From: Amanda Scholes
Sent: 09 March 2012 14:19
To: Planning.Responses
Subject: FW: FG/16/12 - Minor Material Amendment - Asda (Country Fayre), Littlehampton Road, Ferring.

From: Graham Evans
Sent: 02 March 2012 09:56
To: Eve Hearsey
Subject: RE: FG/16/12 - Minor Material Amendment - Asda (Country Fayre), Littlehampton Road, Ferring.

East Elevation

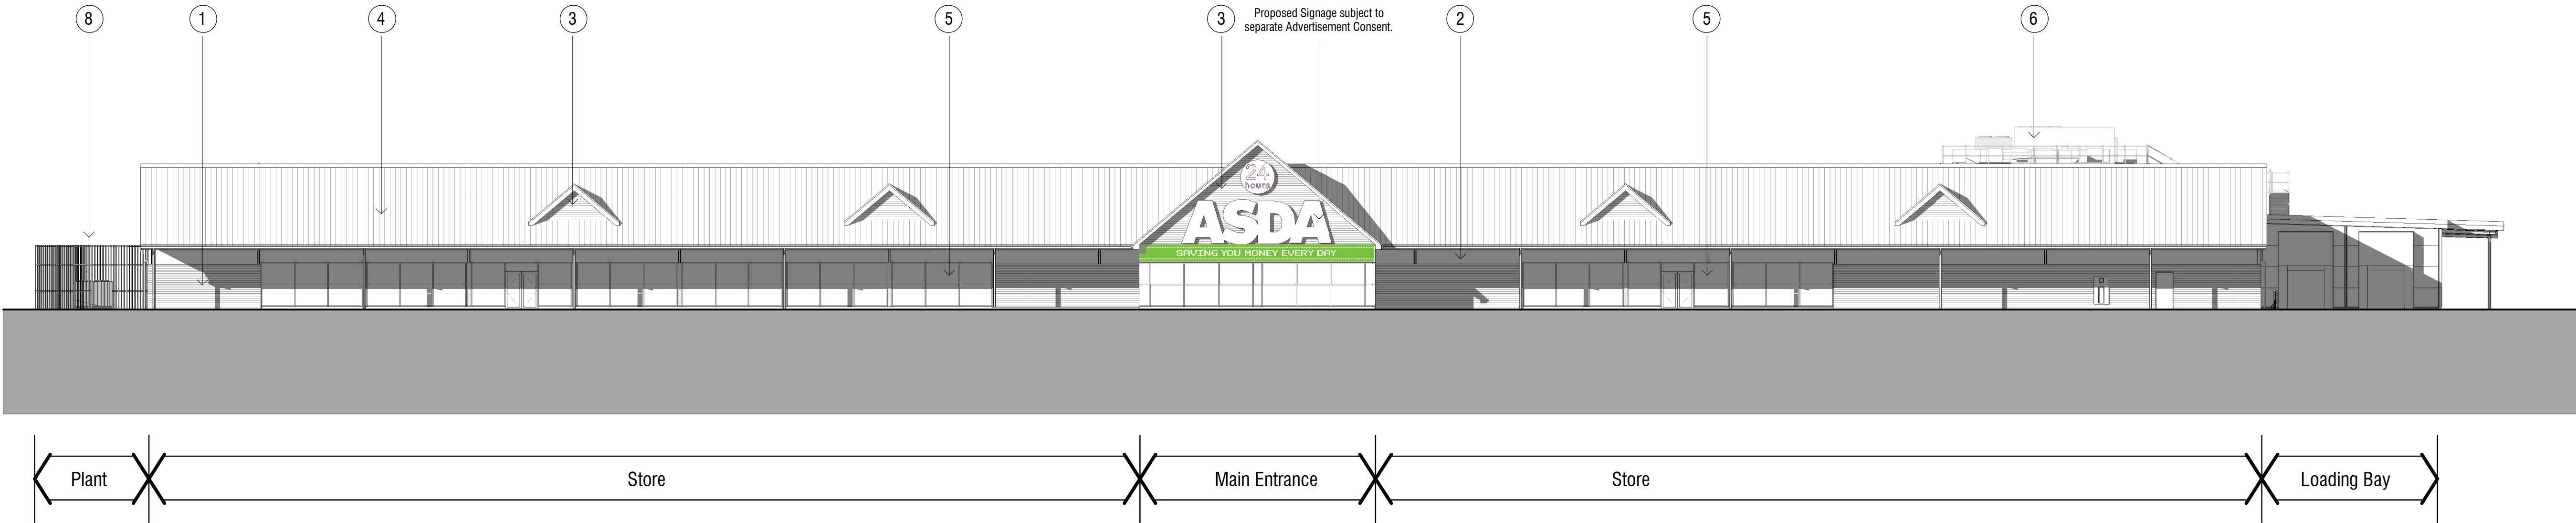
No information is provided in respect of noise produced by the plant, existing background noise levels, or predicted noise levels at nearest sensitive premises, so definitive comment is not possible. It is noted that the scheme does not propose any screening to either plant compound. I did consider the the potential impact of noise from plant and in view of the separation distance to the nearest sensitive residence ("Huntley" @ 100m+?) I did not consider that noise from modern, well maintained plant at this distance was likely to be significant. Noise arising on this site may have a greater impact on future sensitive development in closer proximity and may be a consideration in any application for such development.

You have responded to the above thank you, but I have been asked to check that you have considered both the air conditioning units on the roof together with the refrigeration plant on the east side of the supermarket and the pump room etc. on the west side of the building, particularly with regard to the surrounding residential properties.
